Our ref: NO/2021/113921/01-L01
Your ref: 3/2021/0952
Date: 27 October 2021

**DEMOLITION AND CONVERSION OF FARM BUILDINGS TO EMPLOYMENT SPACE (USE CLASS E) INCLUDING DEMOLITION OF AGRICULTURAL BUILDING AND NEW BUILD WORKSHOP.
ROOT FARM, DUNSOP BRIDGE, CLITHEROE, BB7 3BB**

Environment Agency position

**PROPOSED SITE LAYOUT**

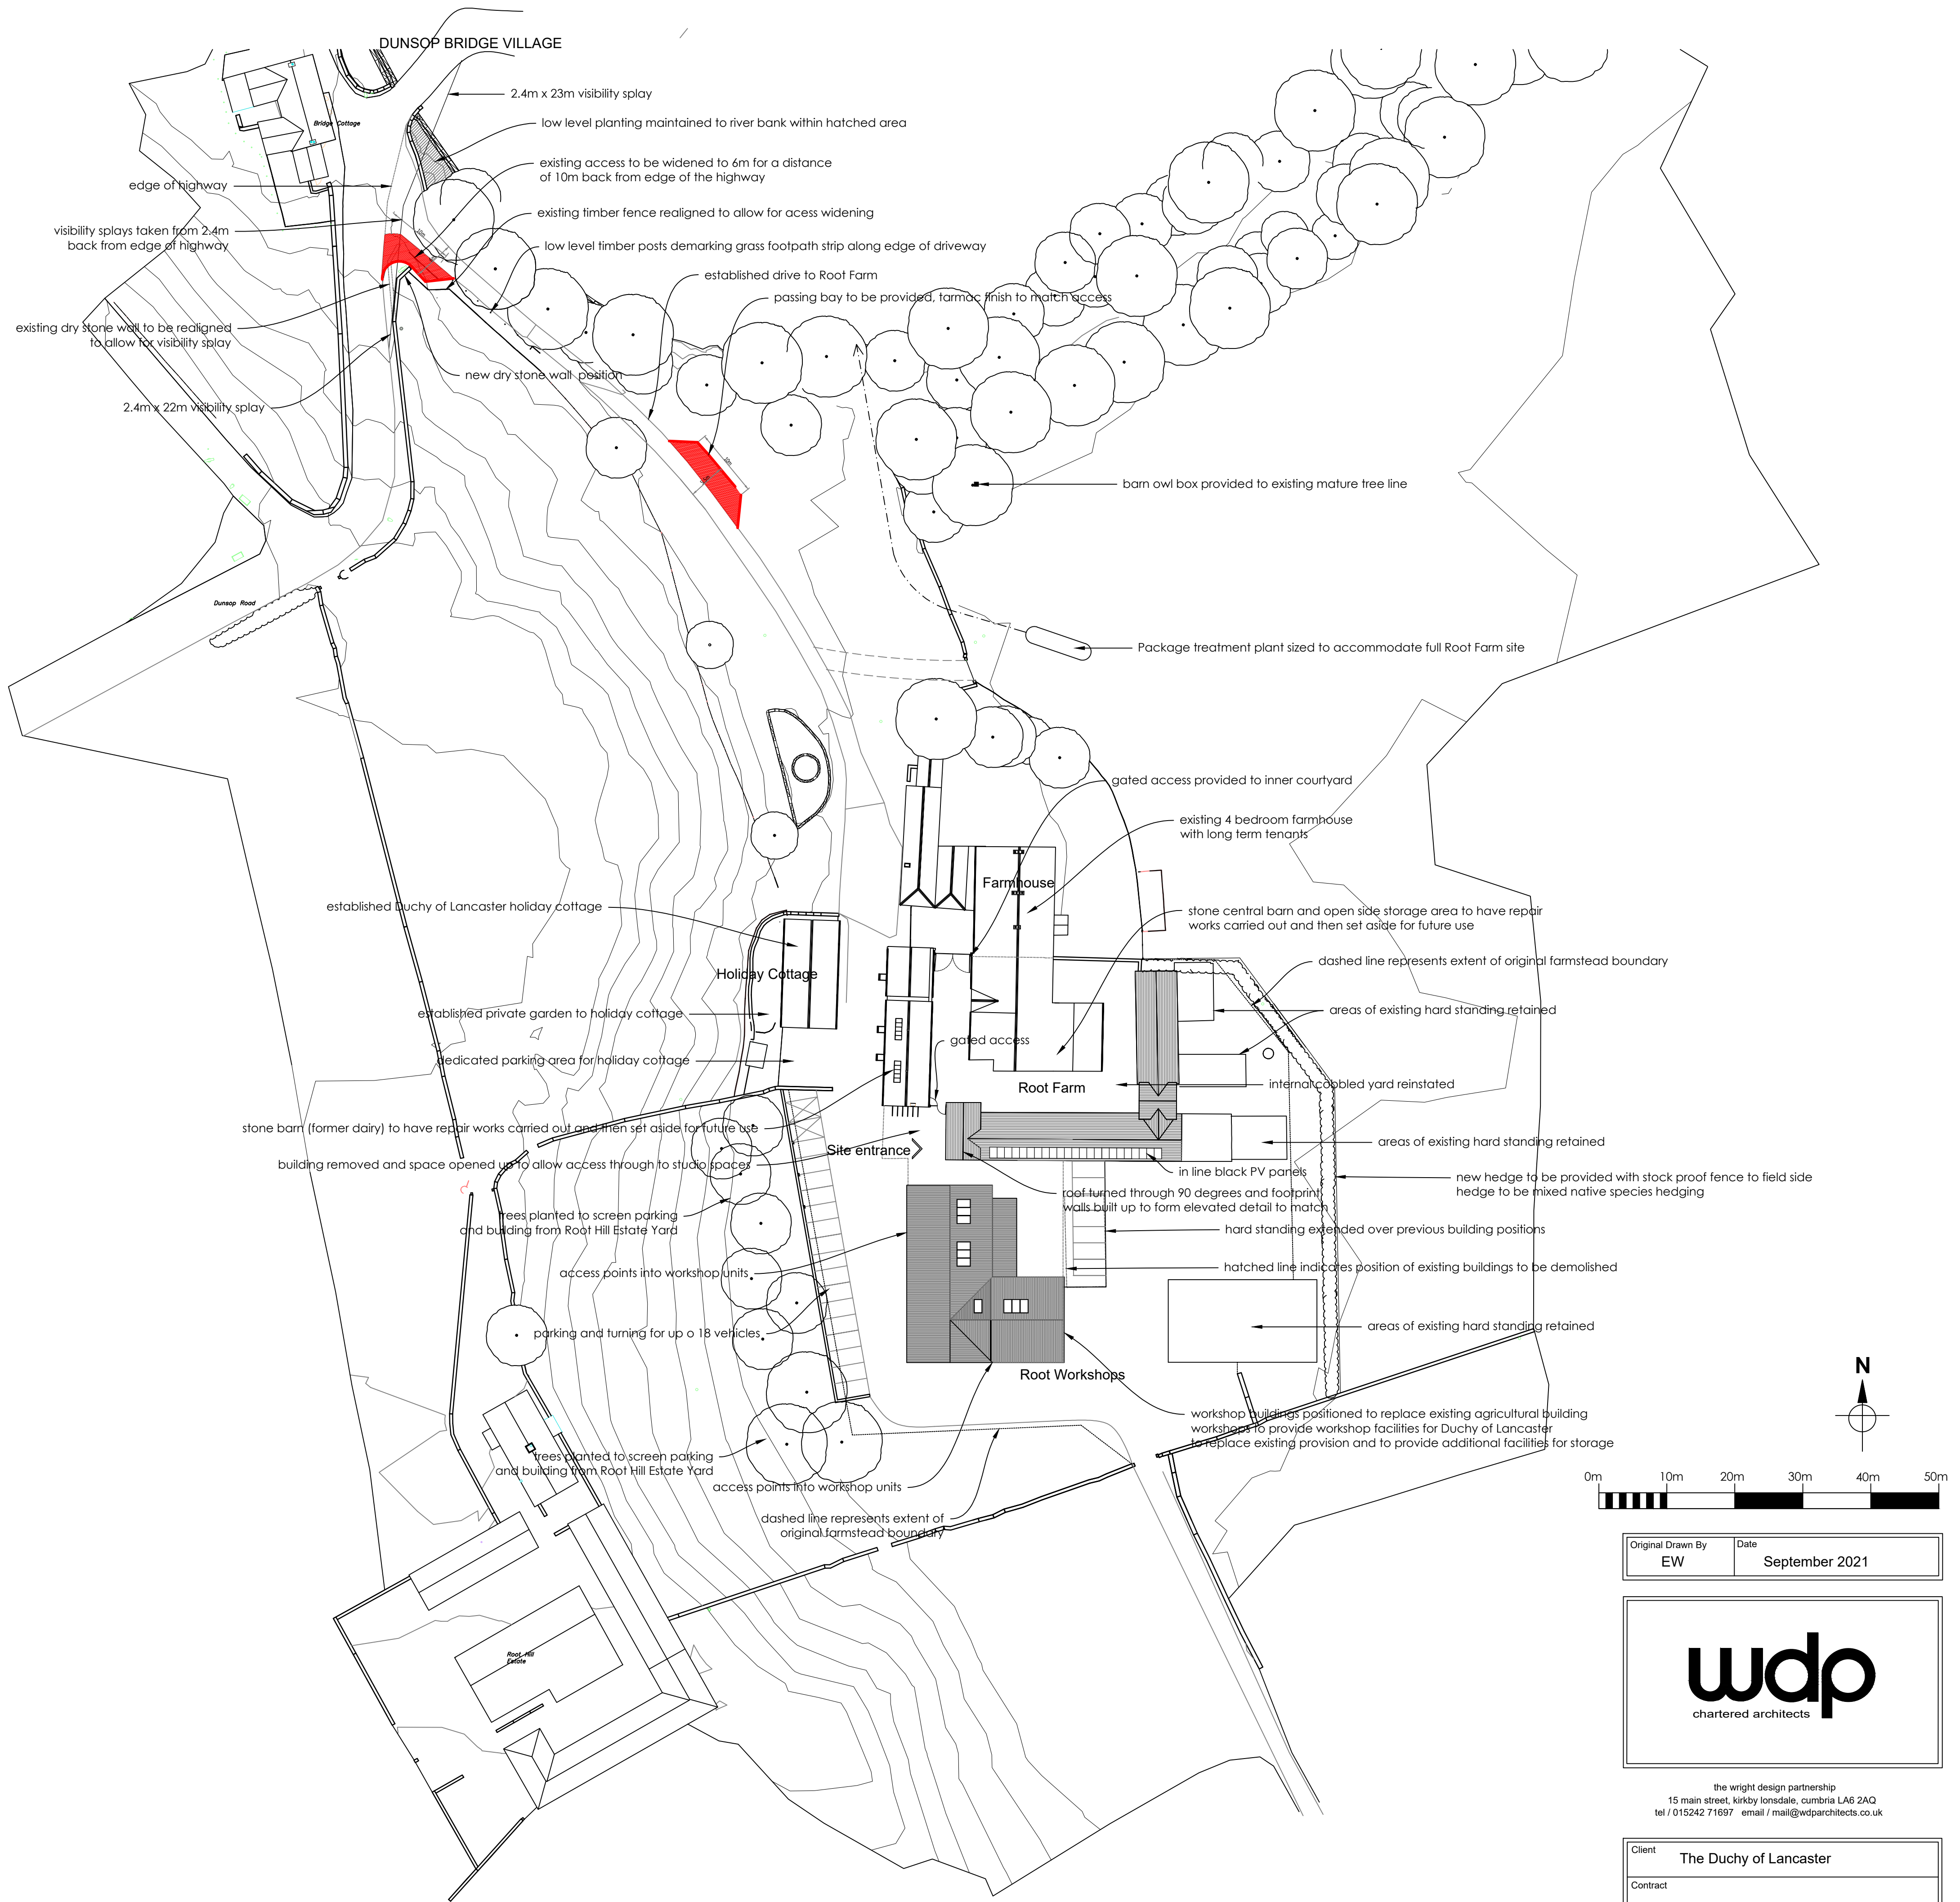
We have no objection to the development as proposed, however we note that the stone wall to the south of the drive way is being altered as part of the planning application. Please note that an Environmental Permit is required for any flood risk activity which will take place within 8 metres of the top of the bank of a main river.

Environmental permit - advice to applicant

The Environmental Permitting (England and Wales) Regulations 2016 require a permit or exemption to be obtained for any activities which will take place:

- on or within 8 metres of a main river (16 metres if tidal)
- on or within 8 metres of a flood defence structure or culverted main river (16 metres if tidal)
- on or within 16 metres of a sea defence
- involving quarrying or excavation within 16 metres of any main river, flood defence (including a remote defence) or culvert
- in a floodplain more than 8 metres from the river bank, culvert or flood defence structure (16 metres if it's a tidal main river) and you don't already have planning permission

The applicant should not assume that a permit will automatically be forthcoming once planning permission has been granted, and we advise them to consult with us at the earliest opportunity.
